# 180 KANATA AVENUE TRANSPORTATION IMPACT ASSESSMENT, STEP 5 – 1ST ROUND COMMENTS

Project No.: CC0-21-3853

Re: Site Plan Control Application – 180 Kanata Ave – 1<sup>st</sup> Review Comments

**Subject: Site Plan Control Application – 180 Kanata Ave - 1<sup>st</sup> Review Comments**

sheet name: SITE PLAN

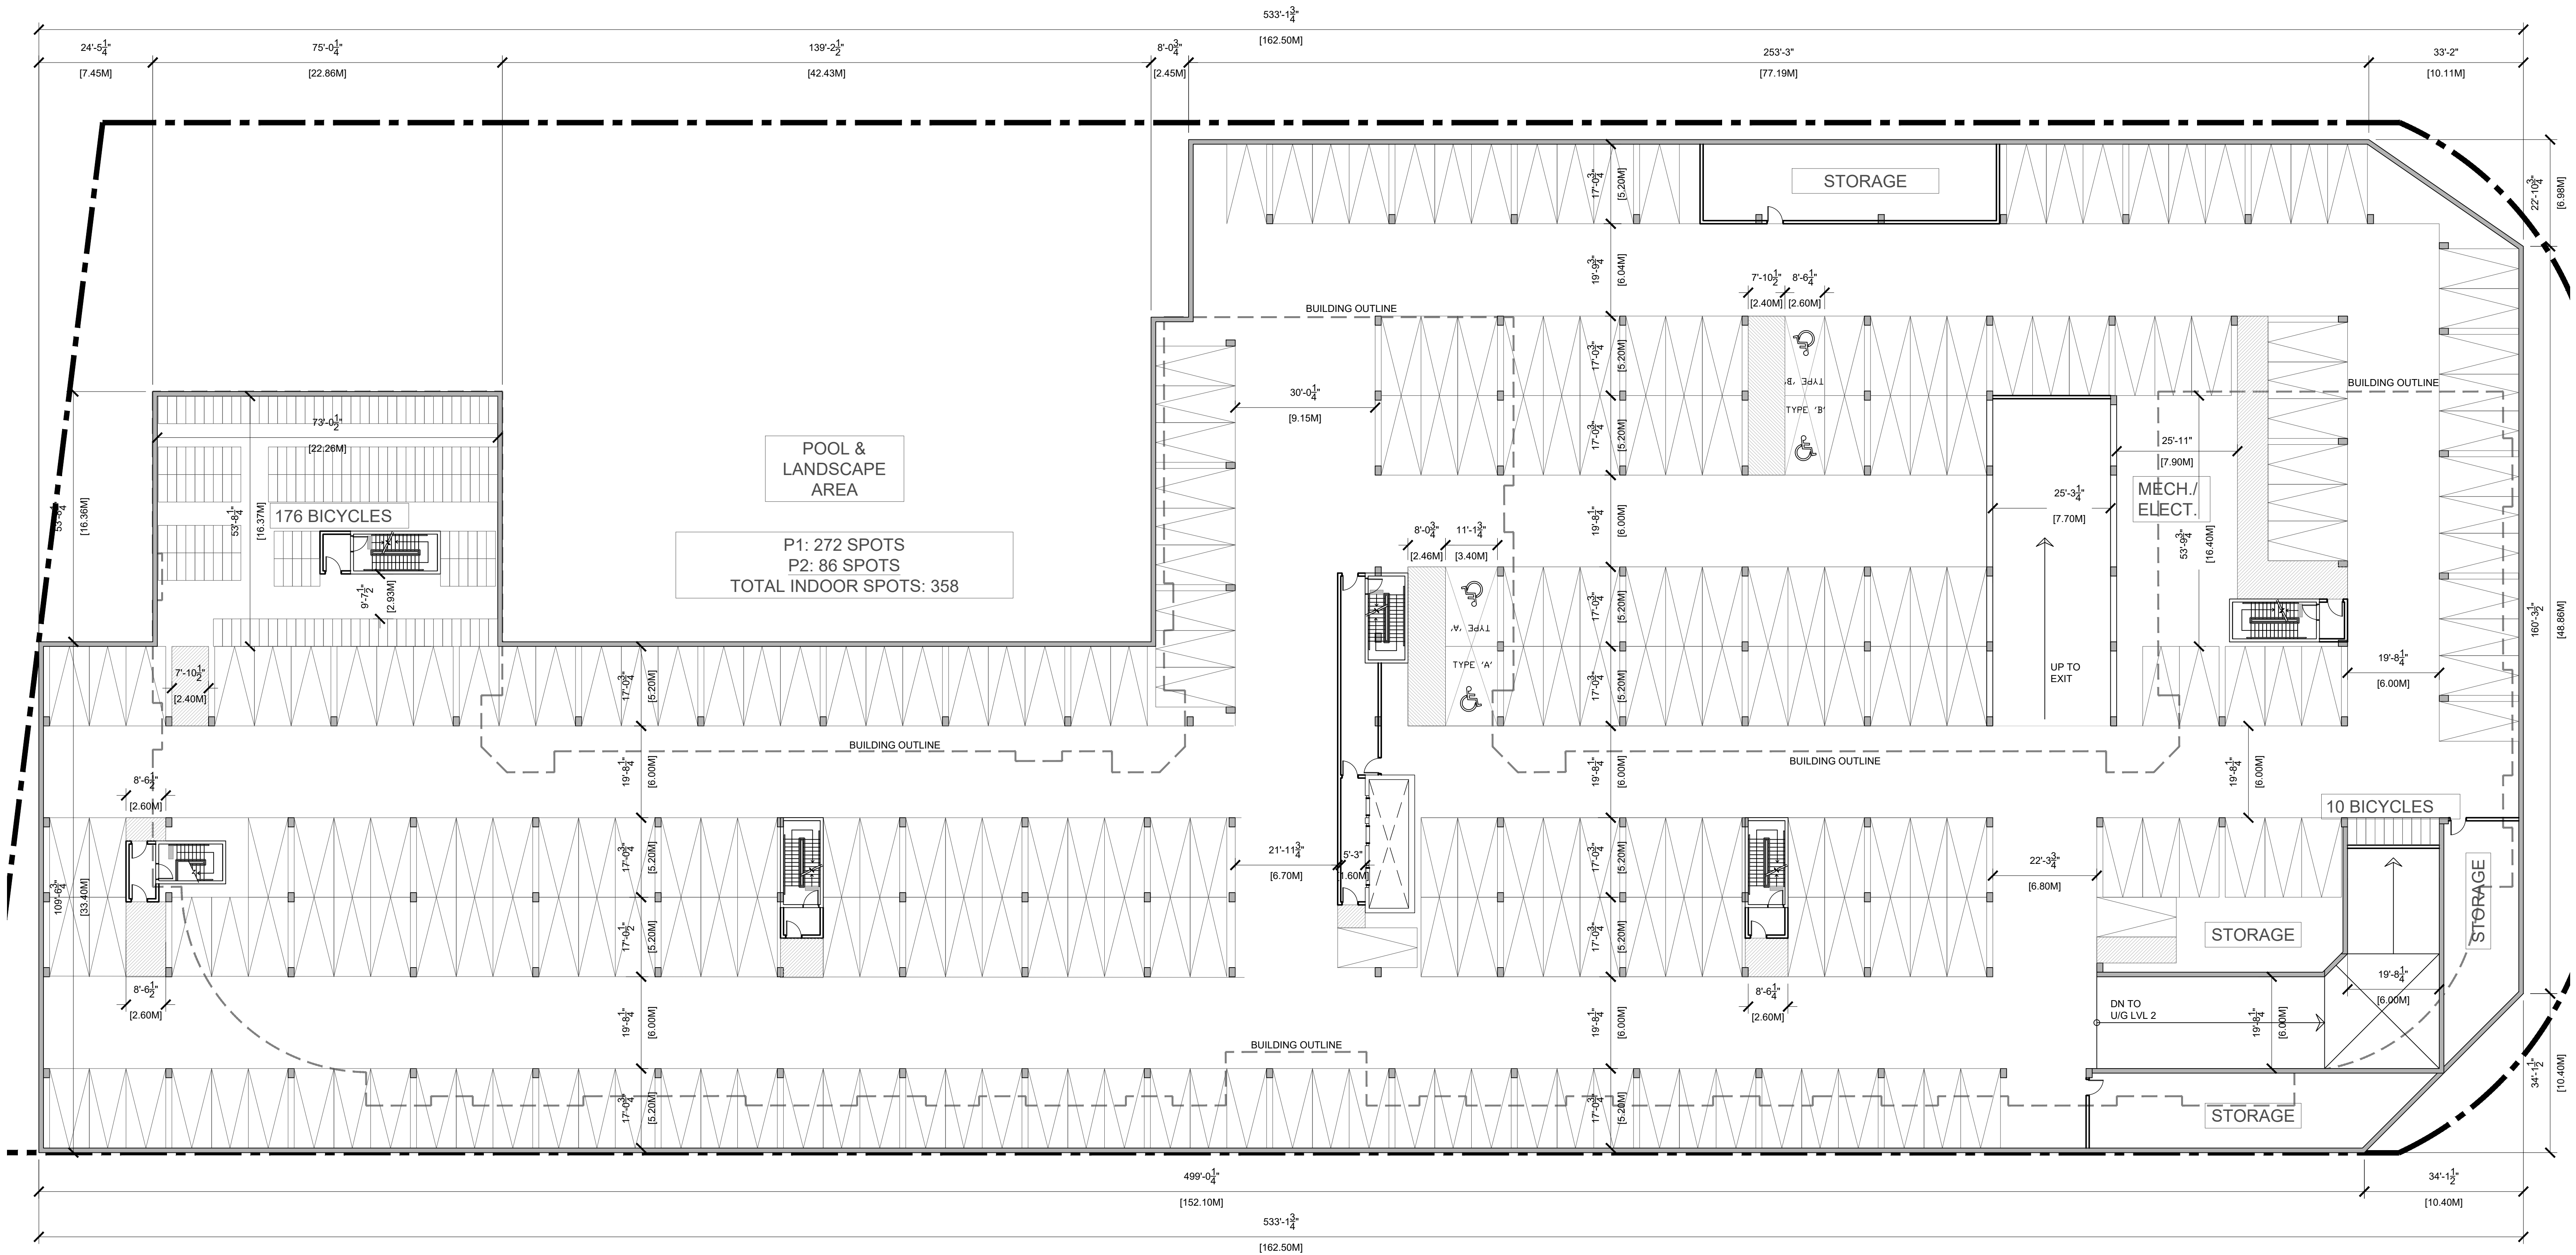
1. It is very difficult to determine the setbacks in the plans provided. Please include minimum (and where required maximum) yard setbacks to the building face.
2. Please indicate the minimum walkway and patio width on the site plan, please include location of depressed curbs.
3. Please provide a unit break down with number of bedrooms.
4. Please show location of commercial accesses on the site plan.
5. Additional separation between the parking garage ramp and walkway should be provided. Please consider landscaping/planters in this area.

project no.:	21-0044
sheet no.:	A-102

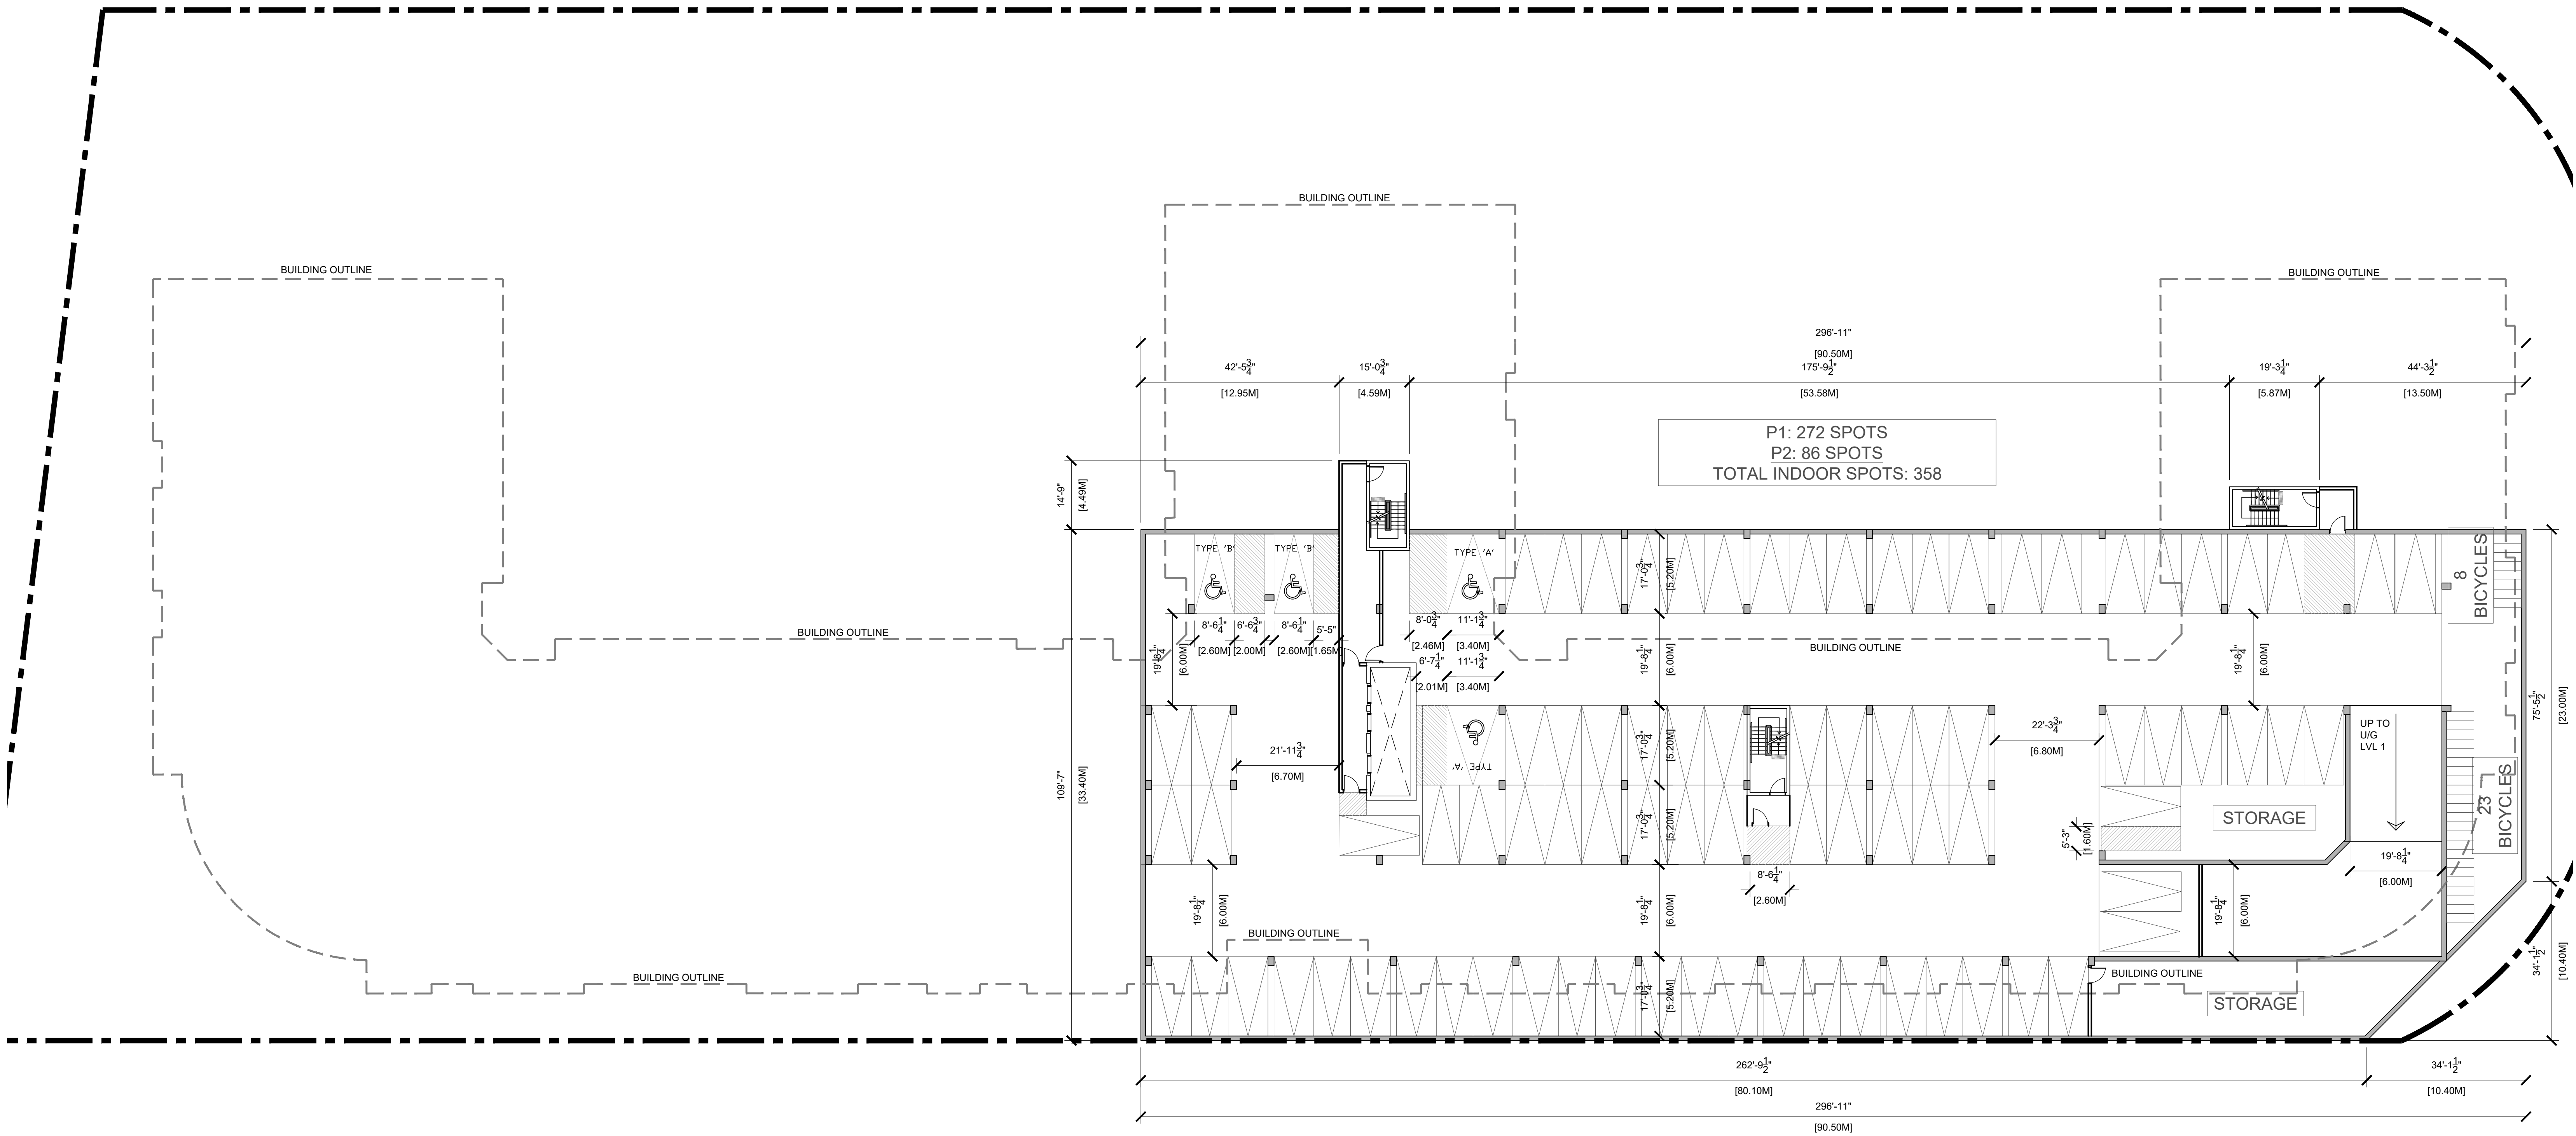
12. On the first floor of the parking garage, please provide the accessible spaces closer to the elevator entrance.

project no.:	21-0044
sheet no.:	A-201

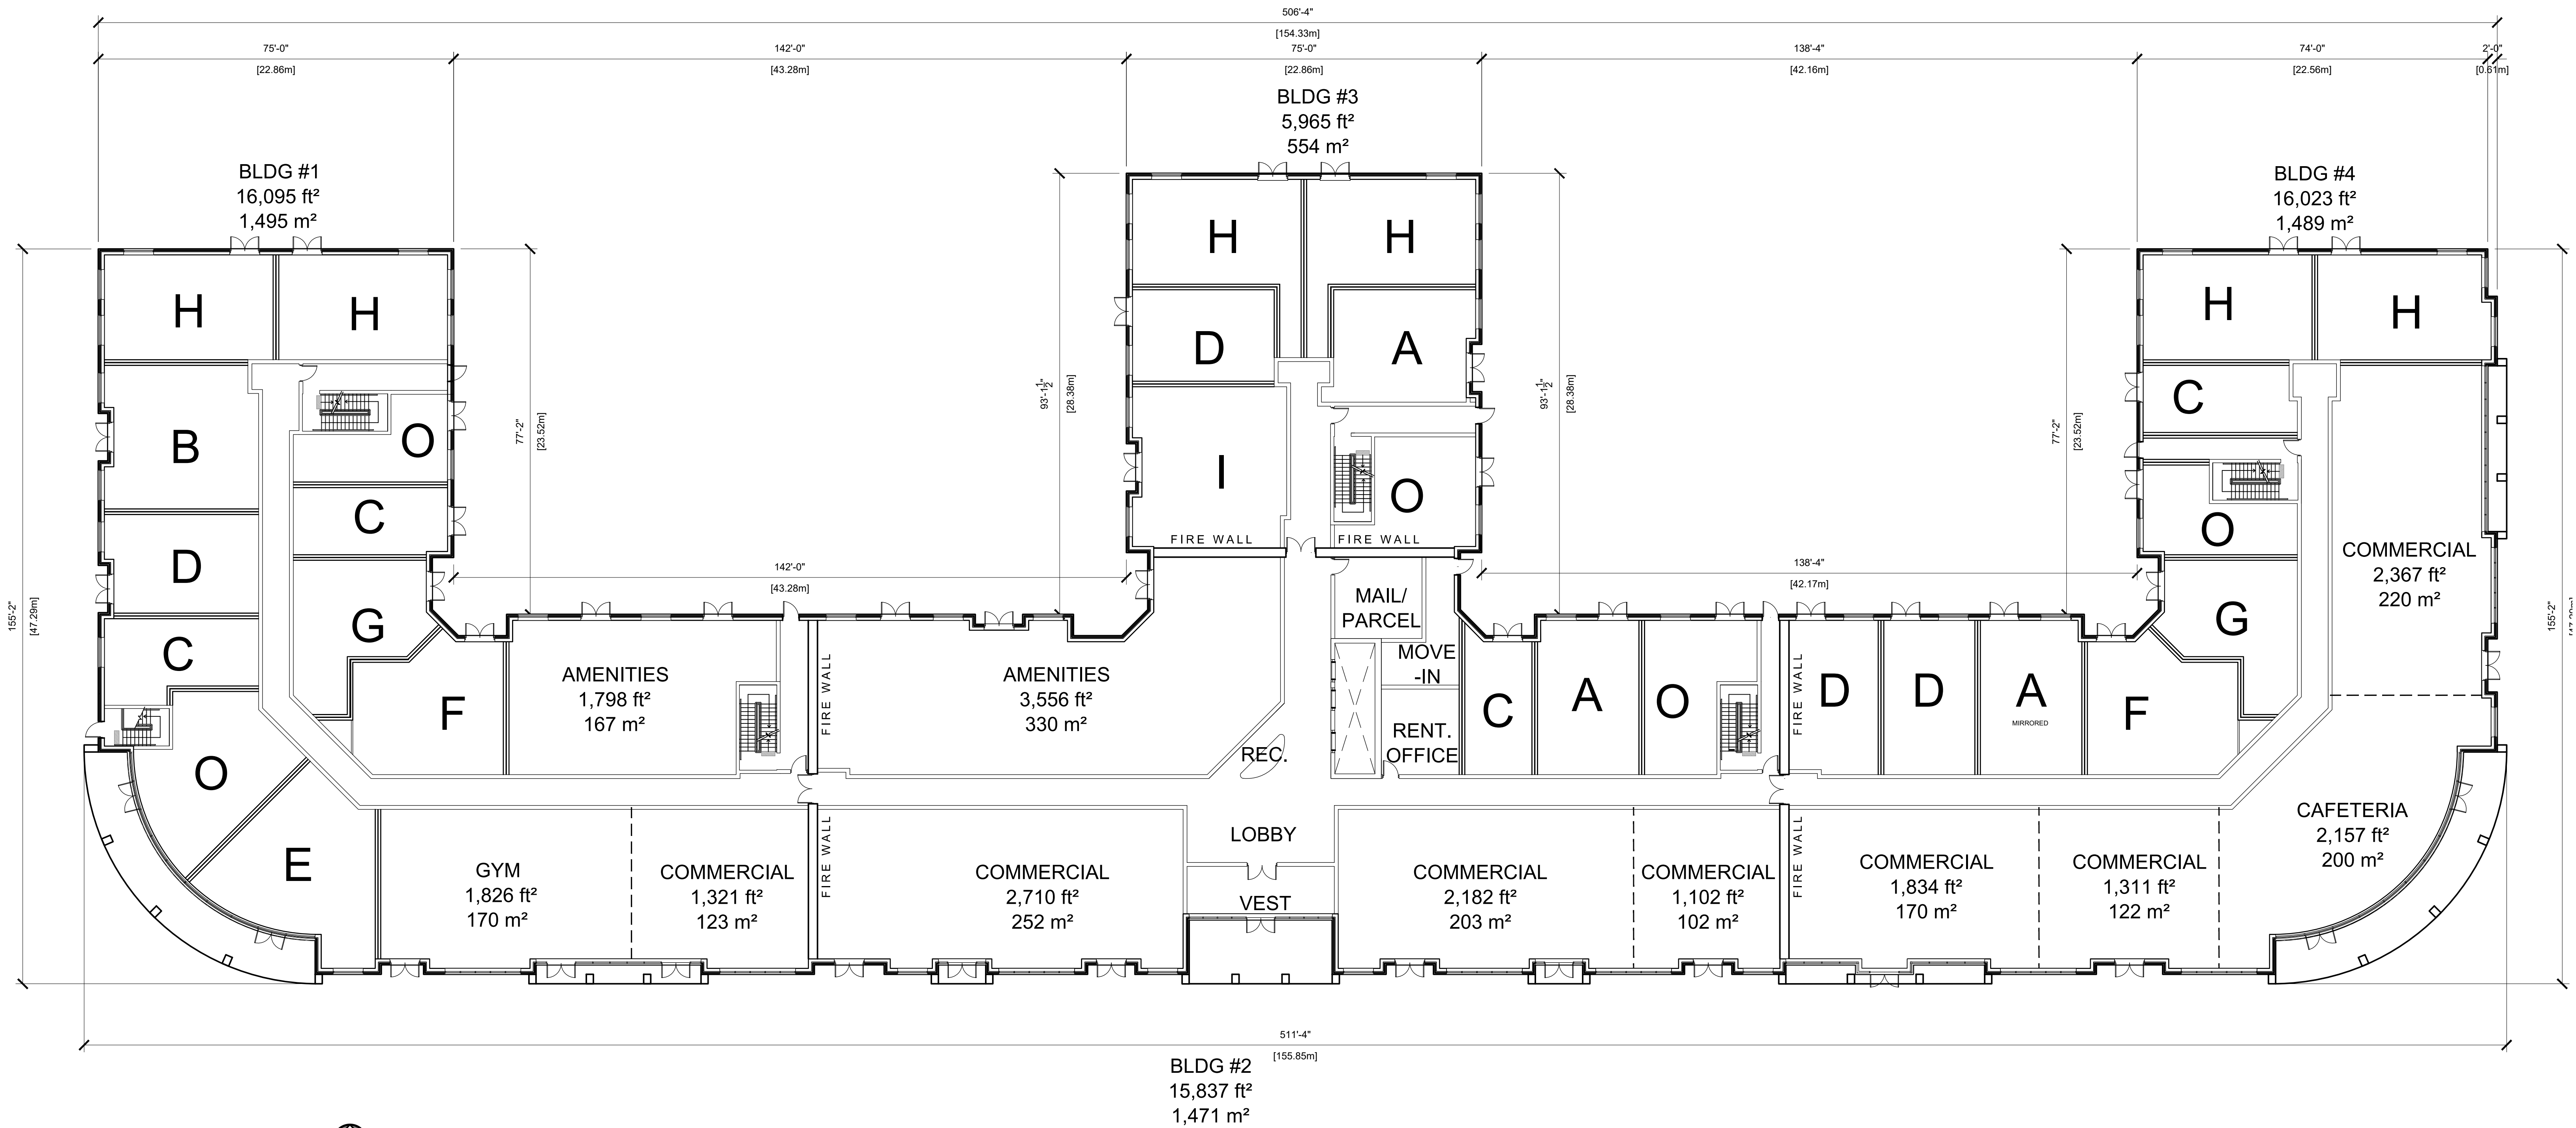
6. It is unclear if there is barrier free access to the commercial units along Campeau.
7. Please provide site sections. Sections as provided in the planning rationale would be helpful to determine the interface with the street frontage and Bill Teron Park.
8. A package of site renderings as included in the planning rationale would be helpful to visualize the “public square”. It appears that the site plan may differ from the renderings provided in the planning rationale. Please see comments below from urban design as related to the POPs.
